**CITY OF ALBUQUERQUE  
PLANNING DEPARTMENT  
March 8, 2006  
DRB Comments**

**PROJECT # 1004722**

**RE: Lots 17 & 18, Block 8, Eastridge Addition, Unit 2/minor plat**

PLAT
 OF
 LOTS 17-A AND 18-A
 BLOCK 8
 DALE J. BELLAMAH'S
 EASTRIDGE UNIT 2
 SECTION 15, TOWNSHIP 10 NORTH, RANGE 2 EAST, N.M.P.M.
 CITY OF ALBUQUERQUE, BERNALILLO COUNTY, NEW MEXICO
 FEBRUARY 2006

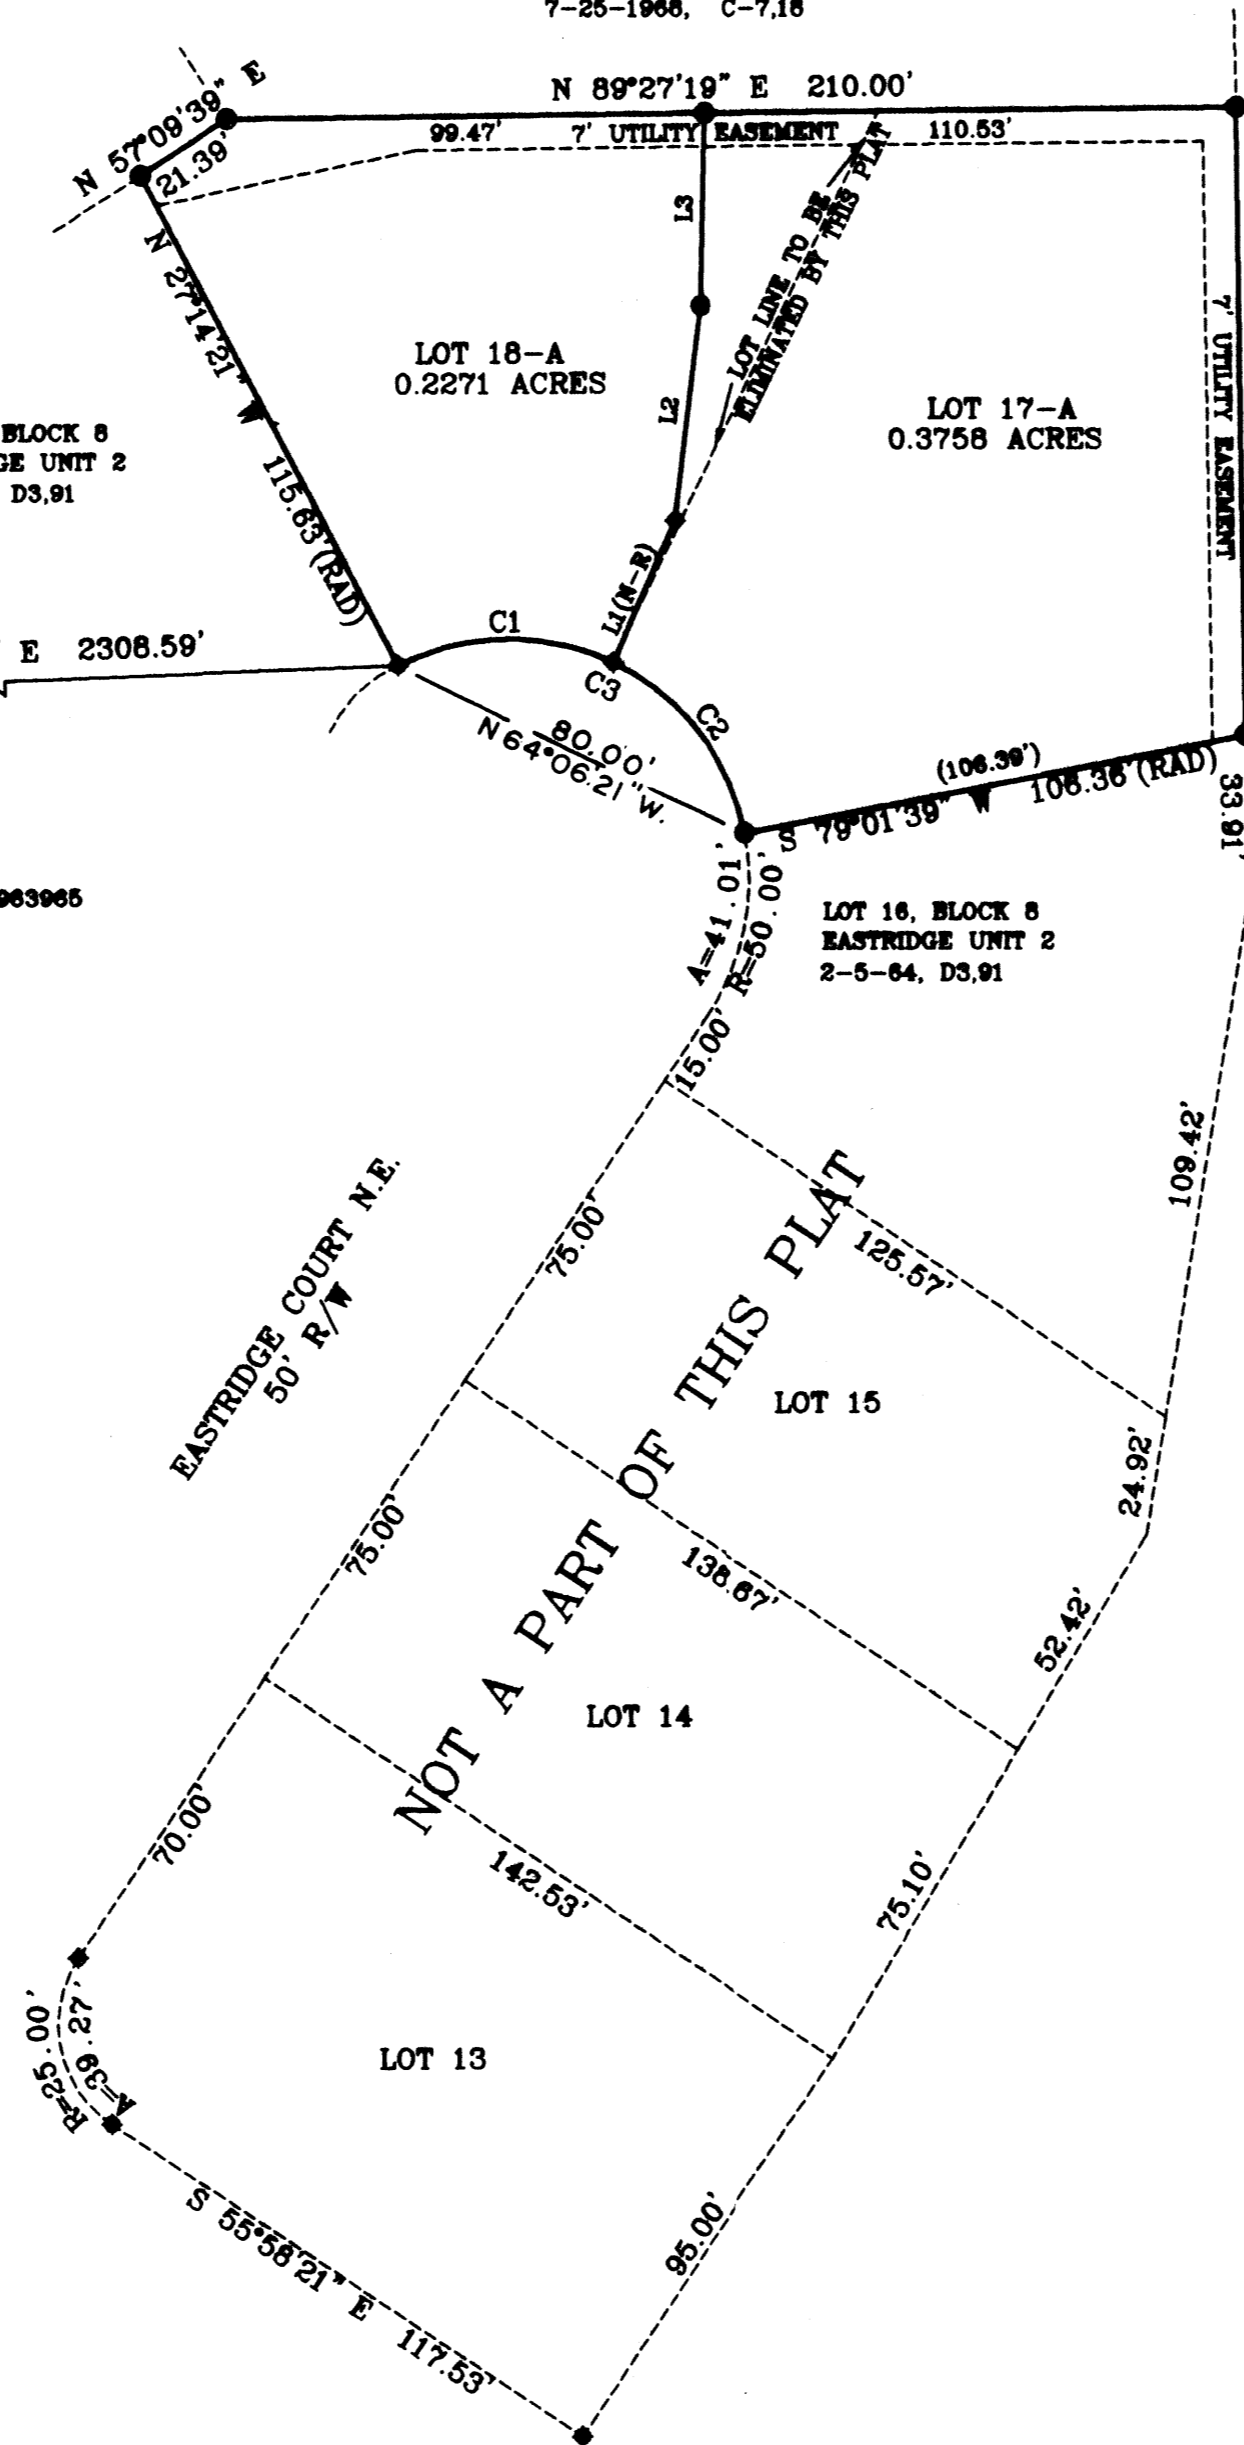
Does the proposed realignment of the lot line respect the required R1 setbacks?
